One Earth Solar Farm

Draft-Final Statement of Common Ground with Anglian Water Services Ltd.

EN010159/APP/8.13.32

December 2025

Figure 2.1 Site Access Location Plan

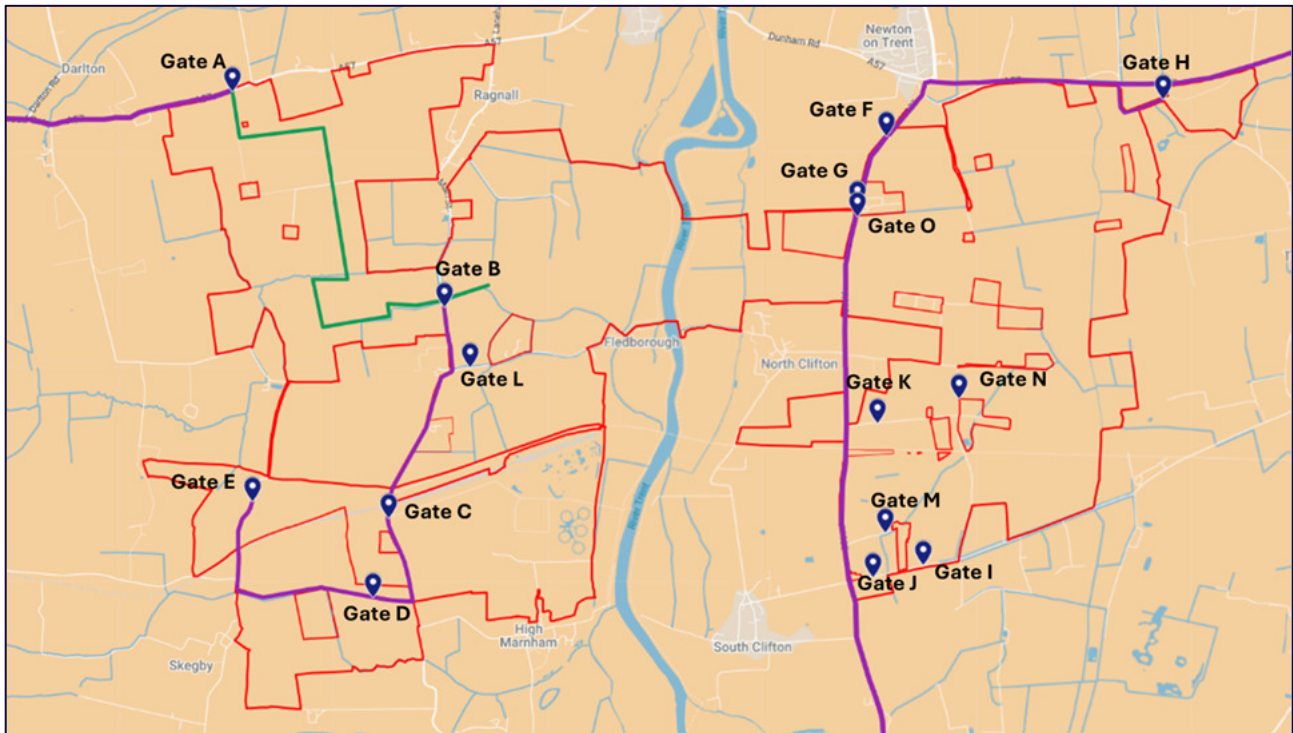
Ref.	Description of Matter	Stakeholder Comment	Applicant's Response	Status
03-06	Proposed access point (Gate G) off the A1133 in the vicinity of Water Reservoir and Hall Water Treatment Works	The masterplan document shows a proposed access point (Gate G) adjacent to the Hall Water Reservoir and this would involve crossing over AWS's pipeline assets. It is proposed to widen the access road and create visibility splays on the track running parallel to the reservoir.	A clarification has been added to the Outline Landscape and Ecology Management Plan submitted at Deadline 5 confirming that the hedgerow north of the access track will be retained, other than a small section marked for removal as shown on the Vegetation Removal Plan in Appendix C of the oLEMP [EN010159/APP/7.7] which will be removed to facilitate the widening of the bell mouth junction. The rest of the access track is proposed to be used in its current condition and therefore no further works to the track are proposed. Therefore, there is no impact on AWS's use of the track to access assets. The Applicant has provided AWS with an access plan of Gate G, which can	<u>Under Discussion</u> <u>Agreed</u>

Ref.	Description of Matter	Stakeholder Comment	Applicant's Response	Status
			also be found at page 112 of the Transport Assessment [REP5-030]. The road junction works are short term and will be programmed in agreement with Anglian Water. Beyond these works, there are no road closures planned for the project and the likelihood of disruption is minimal. Access for emergency works will be unimpeded by the Applicant. The access at Gate G is for landscaping and biodiversity works, and the expected quantum of traffic will be very low, thus unlikely to have any impact on your operational access. <u>The Applicant has confirmed within the oCTMP submitted at Deadline 7 the following – “Engagement with Anglian Water Services and other utilities services where necessary, will be undertaken on a regular basis to ensure their access to their existing and new assets is available throughout the construction</u>
